Application No: AW/66/22/HH
Site Address: 36 Kingsway Aldwick PO21 4DH
Description of works: Addition of a first floor with pitched roof to the existing flat roof garage. This application affects the character & appearance of the Craigweil House Conservation Area.

Thank you for your internet representation made on 19th April 2022 which has been recorded as an objection with the comments as follows:

Proposed West Elevation

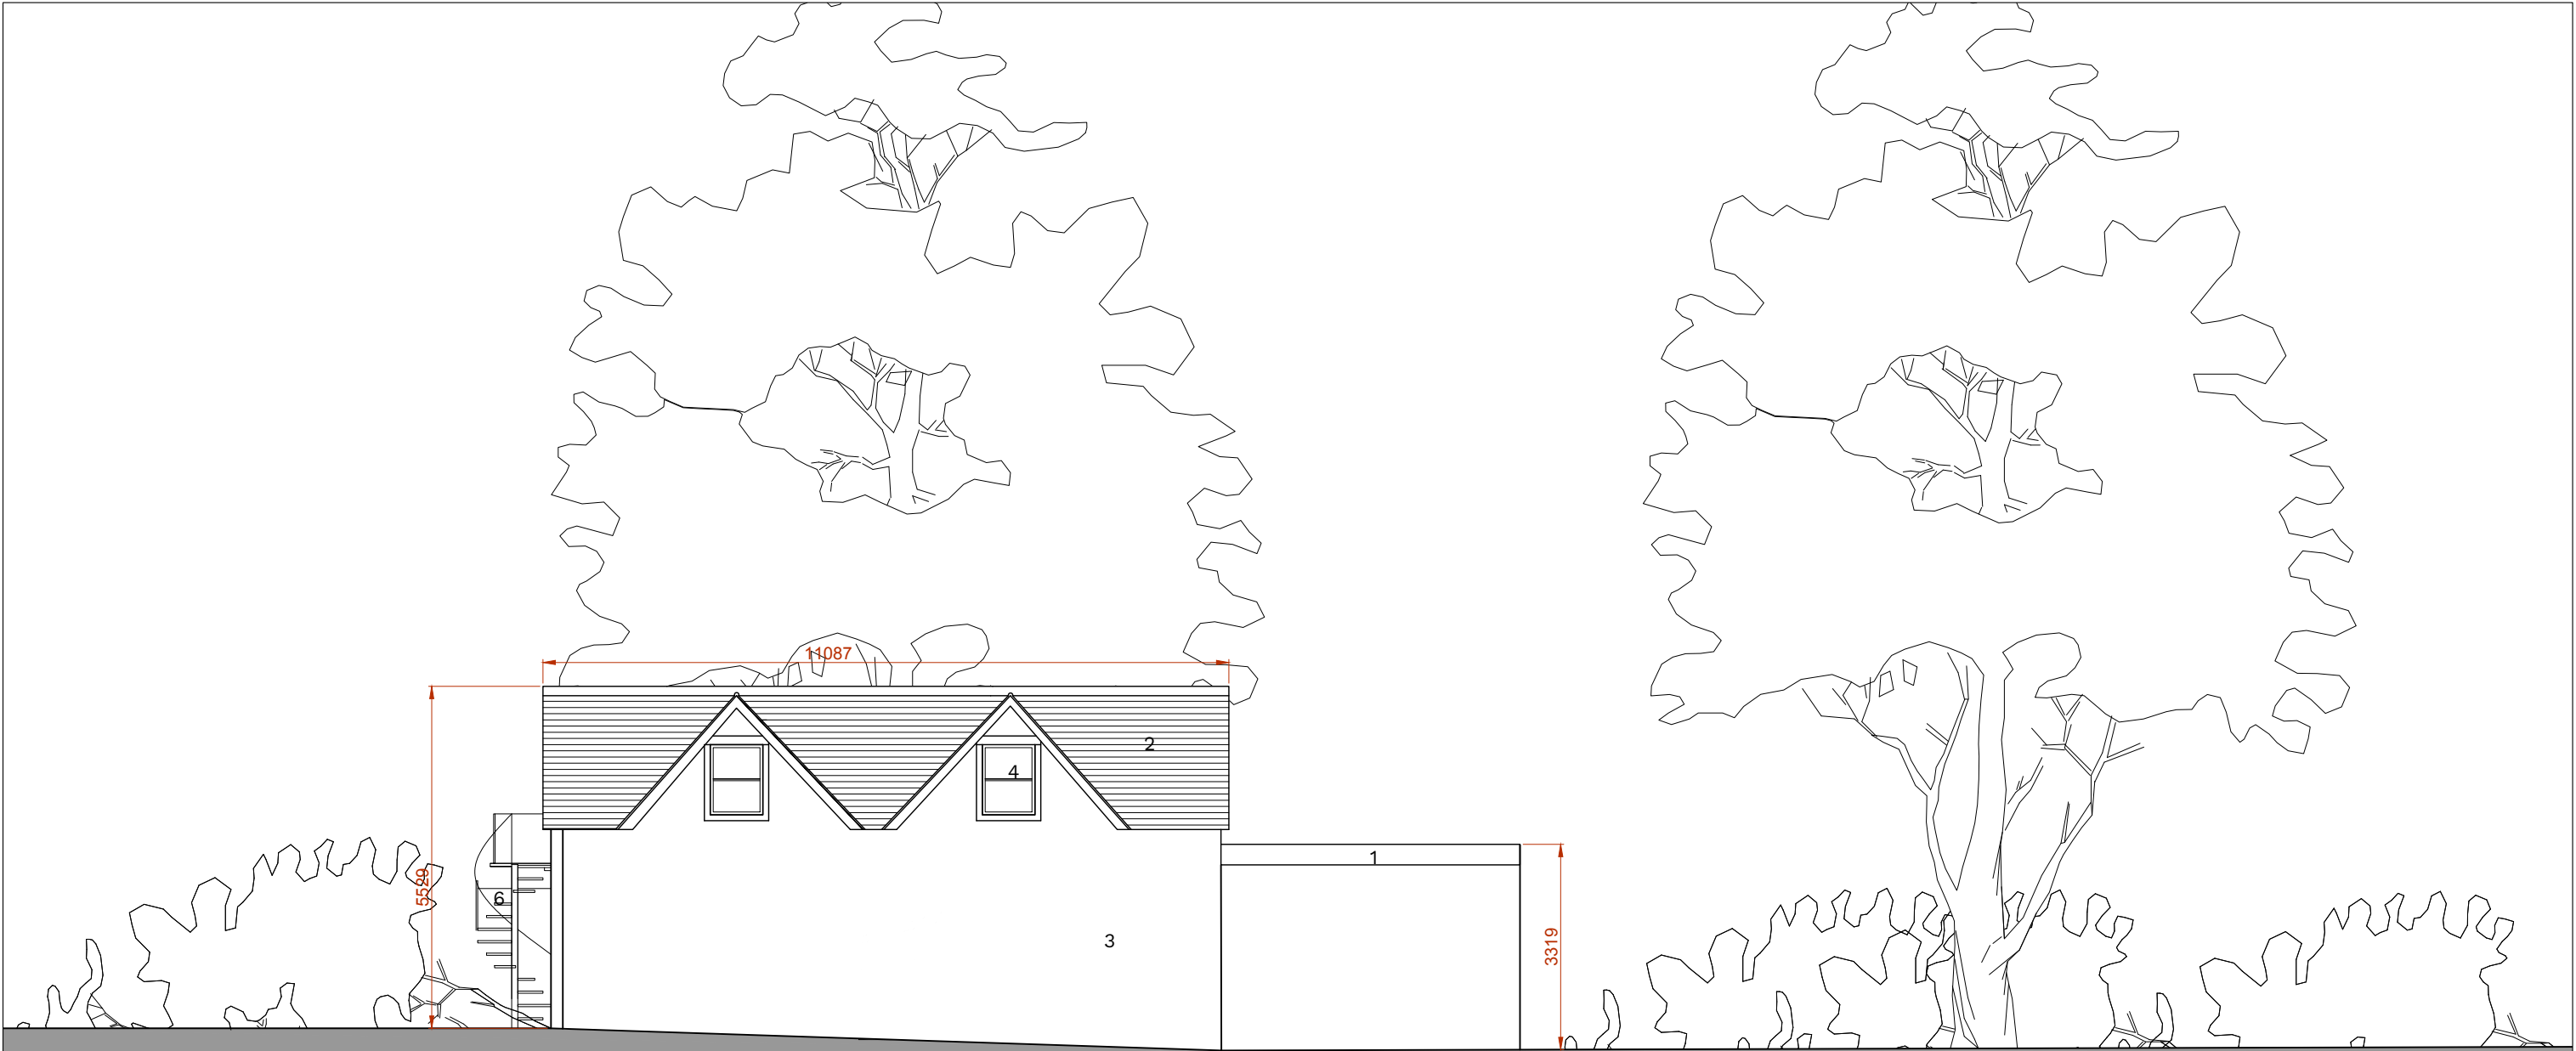
Arun DC is urged to reject this application as it does not conform to what should be expected in planning controls of development in a Conservation Area. The scale of development is inappropriate for its proximity to neighbouring properties. It would adversely impact upon privacy with the staircase, landing and windows overlooking 34 Kingsway.

Drawing Details
Proposed First Floor Plan
PLANNING ISSUE

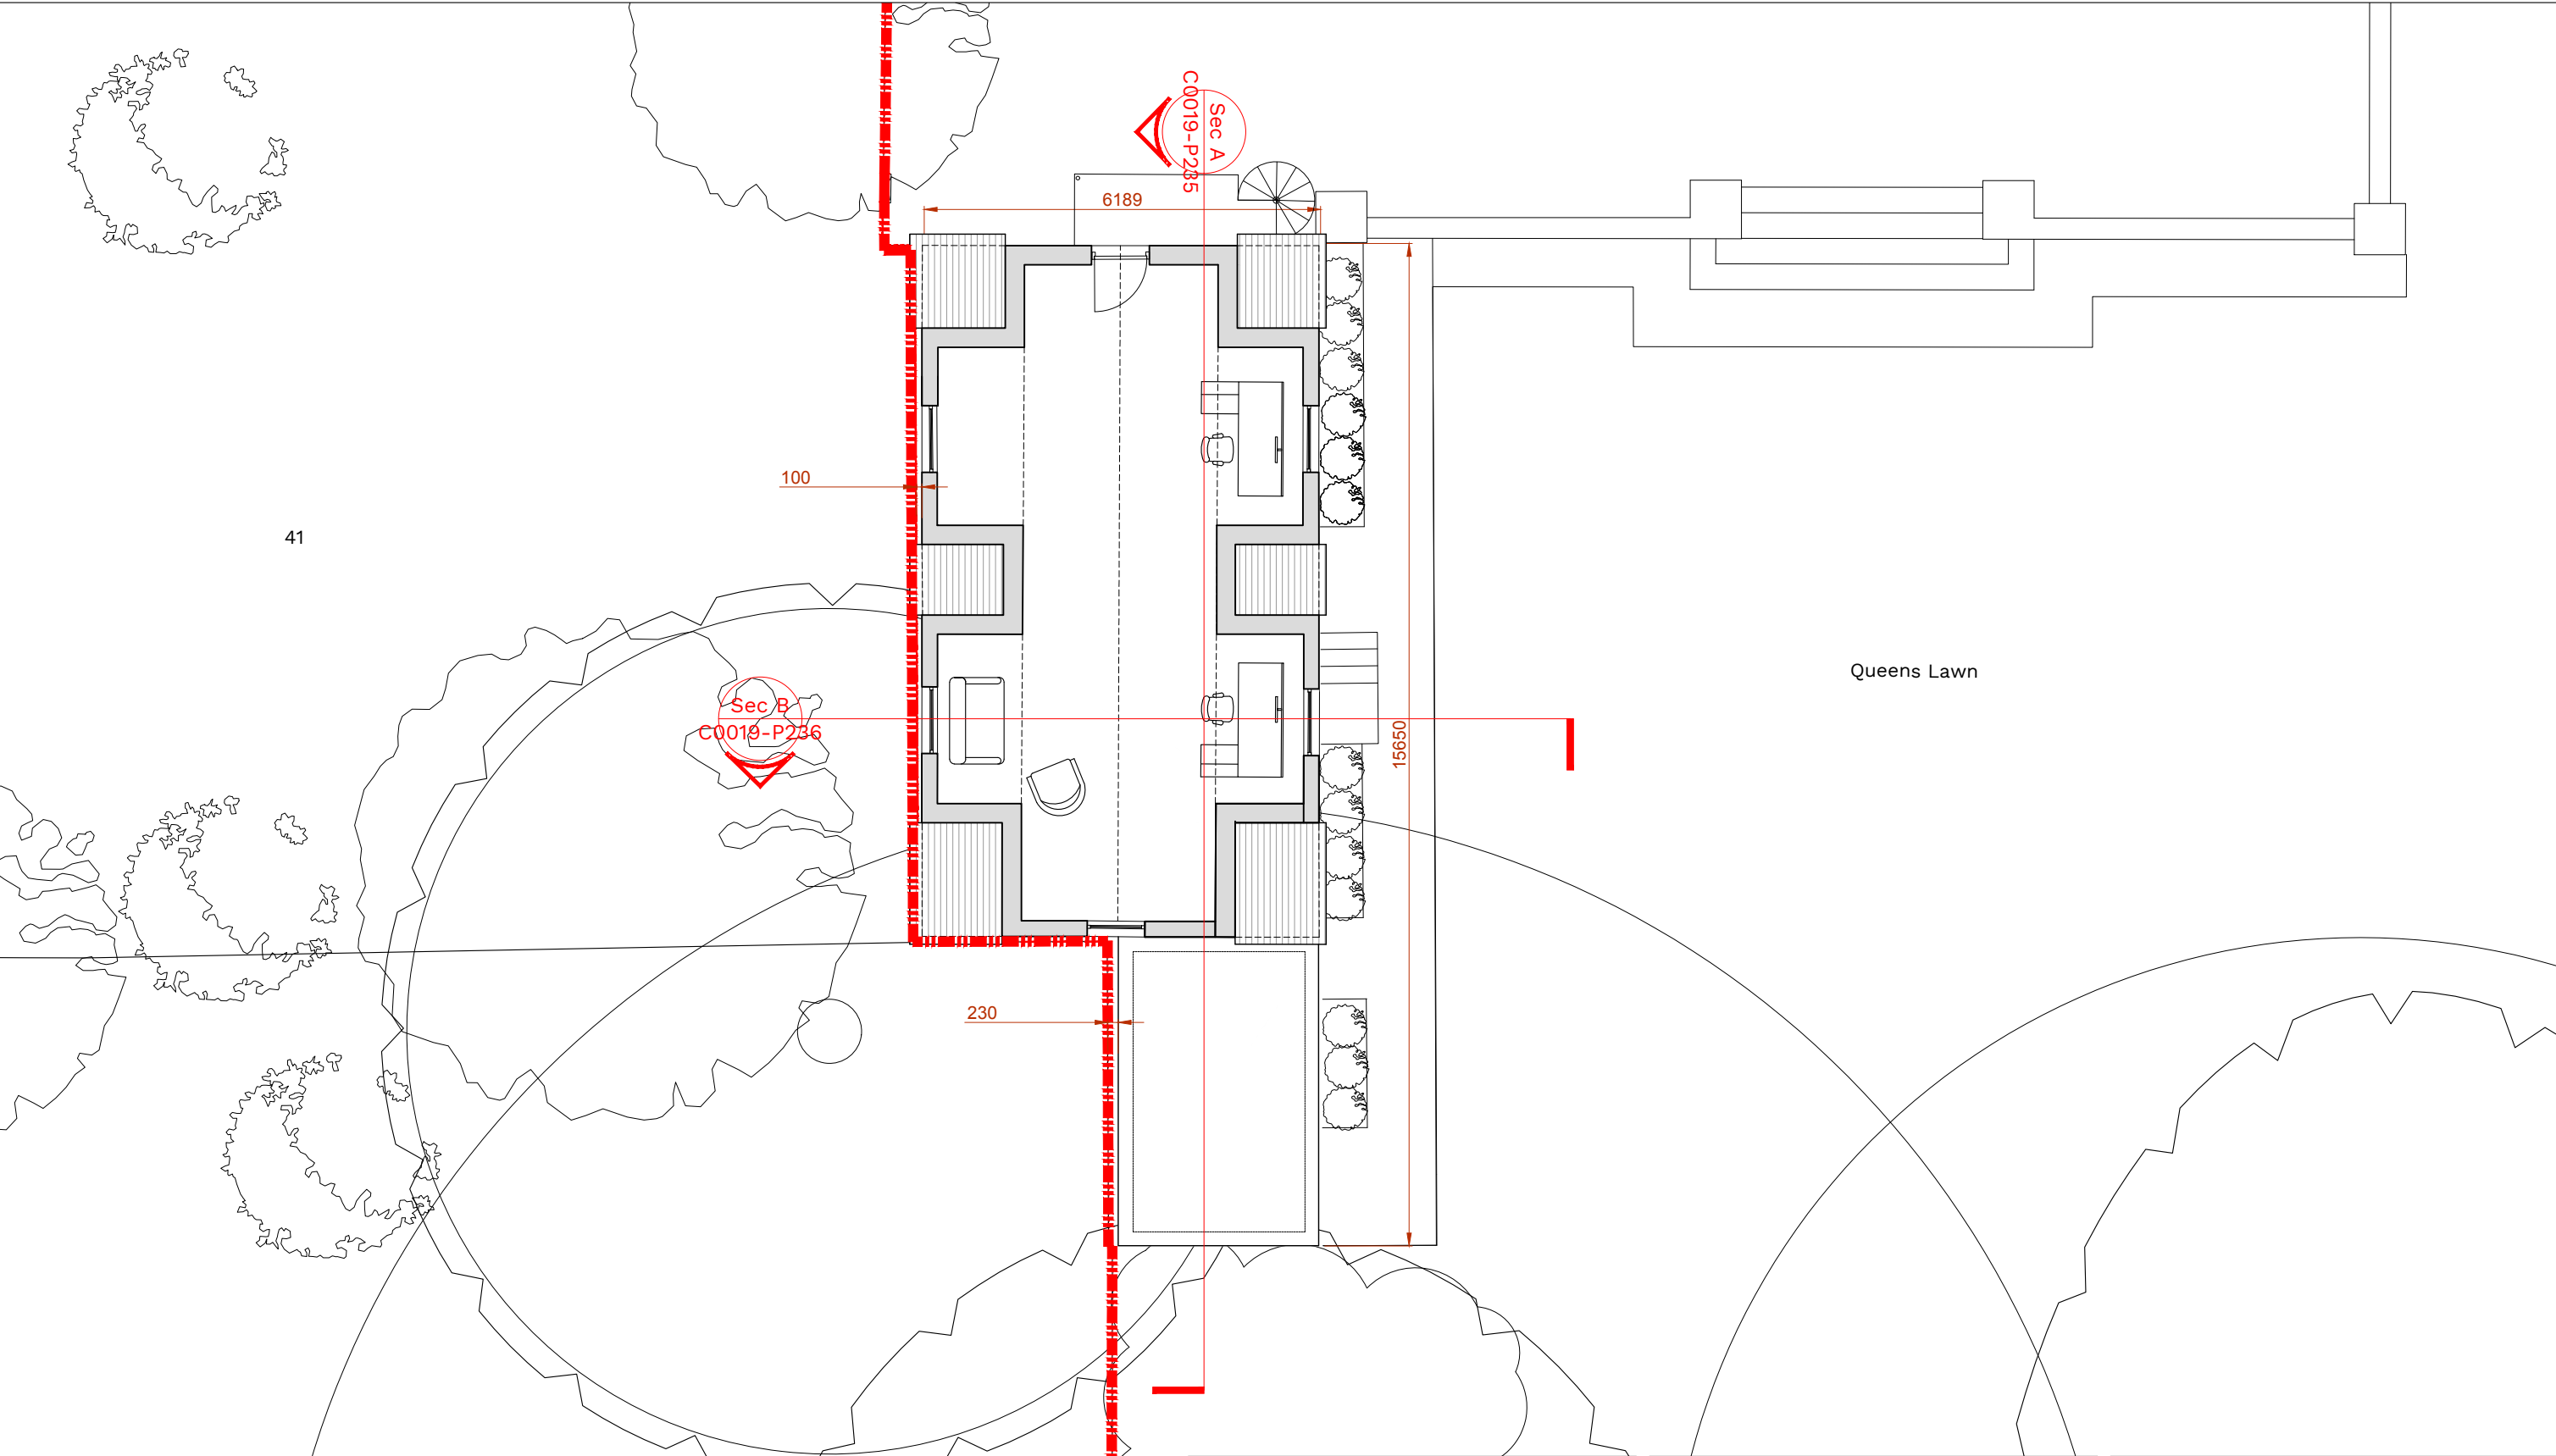
The proposed floorspace is more akin to a commercial office rather than the 'home office' description and should therefore require a Change of Use application.
